Re: Huntlee residential subdivision – Stage 1 MOD 9 (MP 10_0137)

Northrop Consulting Engineers have prepared the following letter in response to the comments made in review of the Huntlee Residential Subdivision Stage 1 MOD 9 Application (MP 10_0137). This letter intends to provide the additional information requested in relation to the stormwater and flooding concerns raised and should be read in conjunction with the attached Tributary 1 and 2 Flood Inundation and Stormwater Strategy Plans.

INDICATIVE BUILDING AREAS ABOVE
THE INDICATIVE 1% AEP FOR AFFECTED LOTS

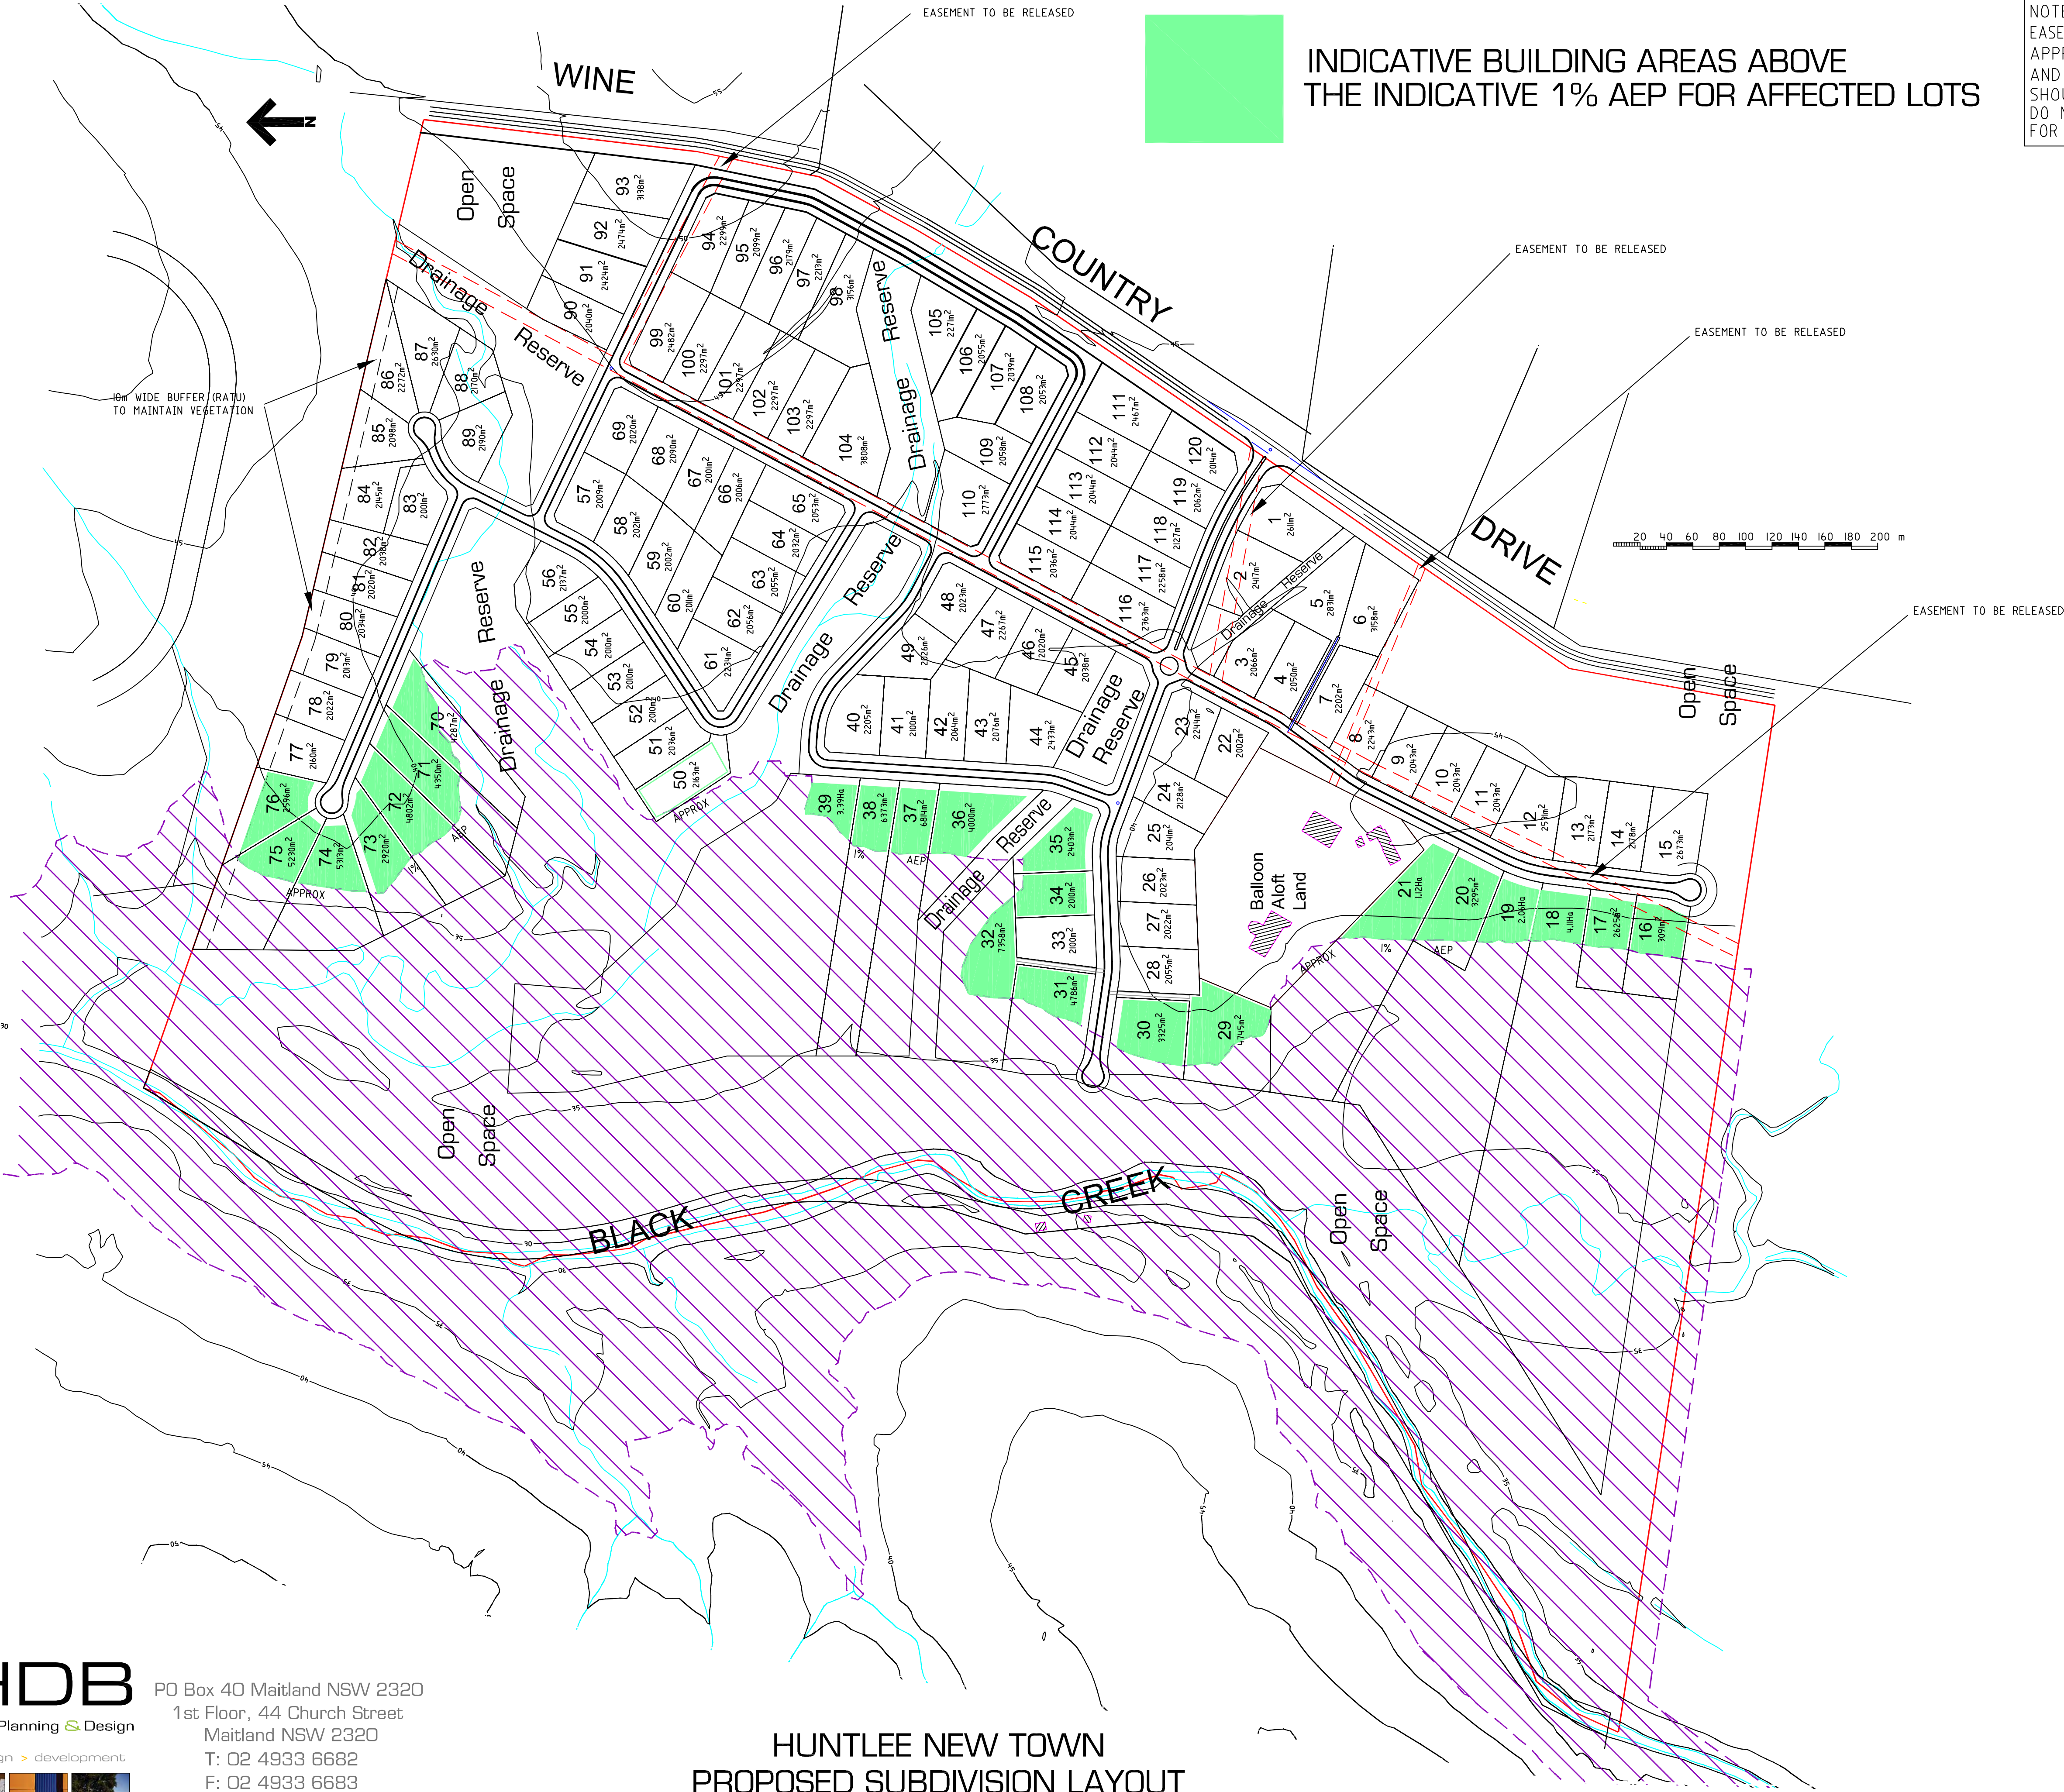
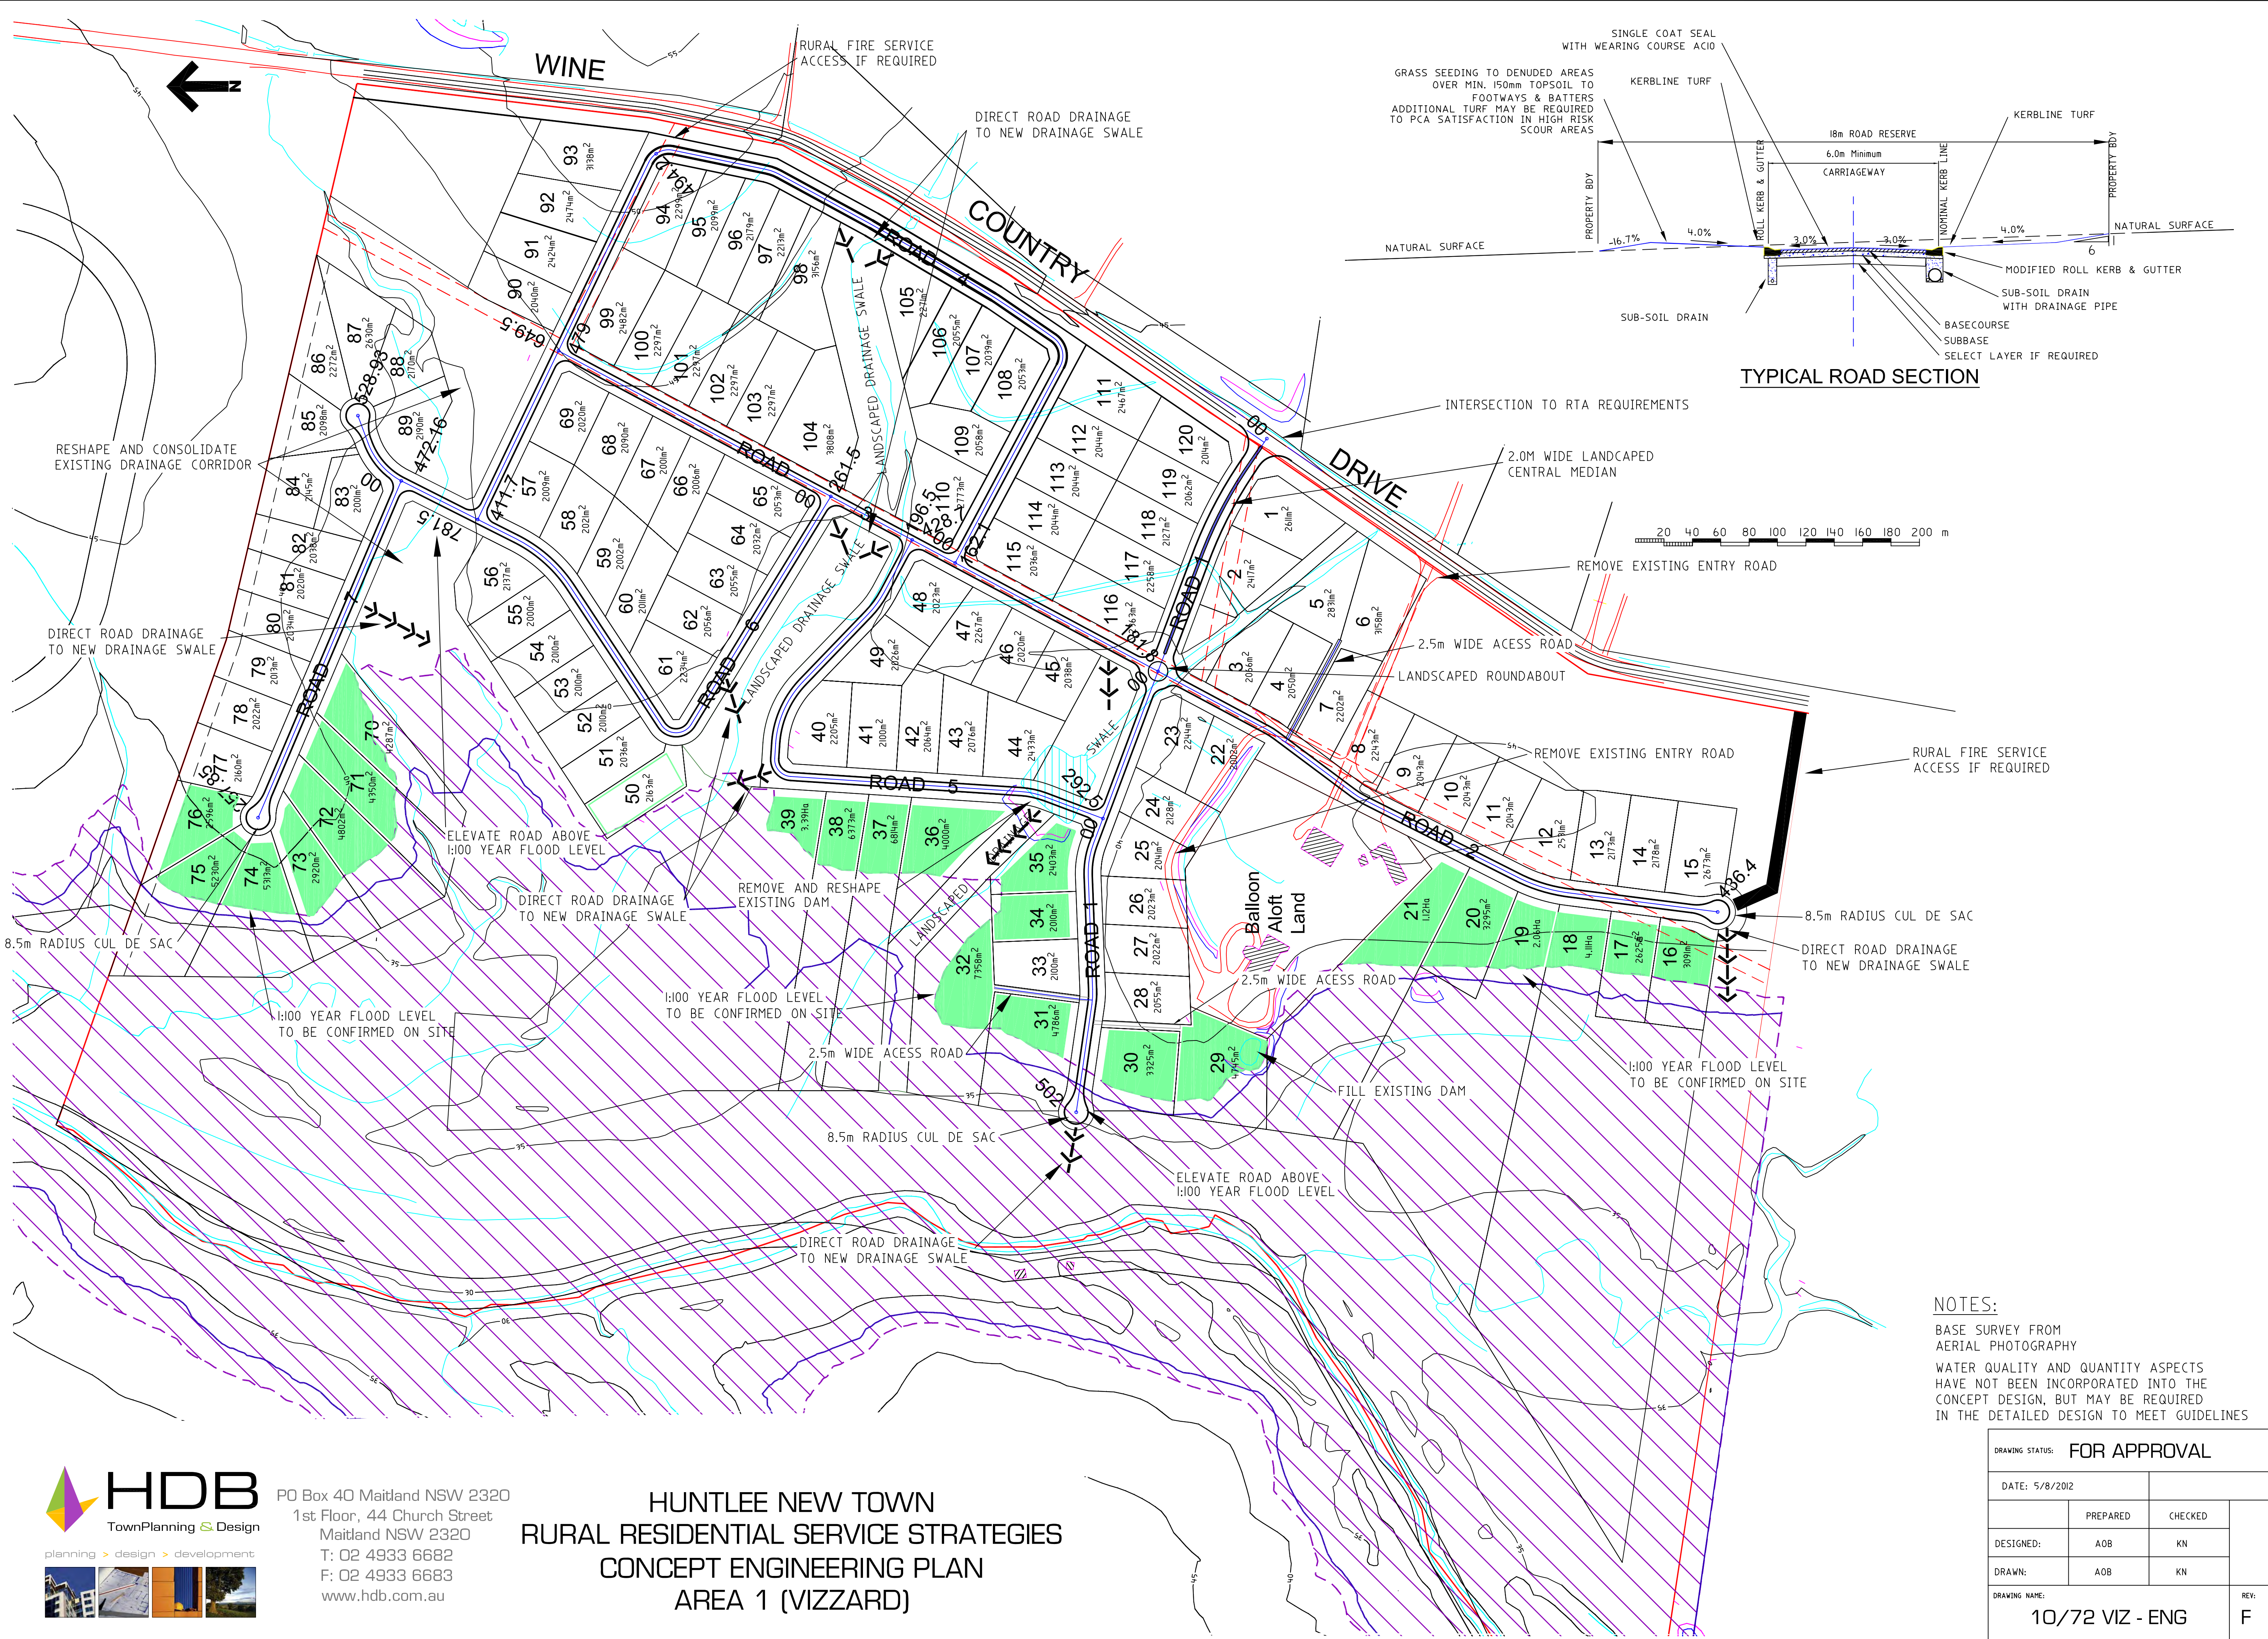
3.4 (Precinct 16) – Please provide an updated flood assessment to show the extent of flood risk to all new lots, and submit a plan showing the levels and demonstrate there would be no significant changes in levels or benching required to establish the new lots.

Updated flood information (100 Year Flood Extent and PMF) relating to the Huntlee estate should be provided with every modification to the subdivision layout and should take into account any additional stormwater infrastructure, such as detention basins. Council requires this information to assess the impact of flooding on individual allotments within the estate and for emergency planning and management.

Future development of lots within Huntlee are to be assessed under independent development applications. All flood affected lots are expected to take the flood inundation extents into consideration in order to establish minimum habitable floor levels or appropriate land uses. To aid in assessment of the proposed new lots preliminary flood inundation extents for both the 1% AEP and PMF storm events have been provided – please refer attached Tributary 2 Flood Extent Plan.

As illustrated in the attached, the 1% AEP storm event is not anticipated to have any impact upon the proposed lot within Precinct 16, with only a minor encroachment anticipated during the PMF storm event. No significant changes in levels or benching would therefore be considered necessary to establish the lots.

The one-dimensional model prepared for the 2015 study 'Catchment Analysis for Online Detention Basin' prepared by Northrop has been updated to include the PMF event. Again, as illustrated the 1% AEP storm event is not anticipated to have any impact upon the proposed new lots with only minor encroachments anticipated during the PMF storm event. No significant changes in level or benching would therefore be considered necessary to establish habitable dwellings within these new lots.
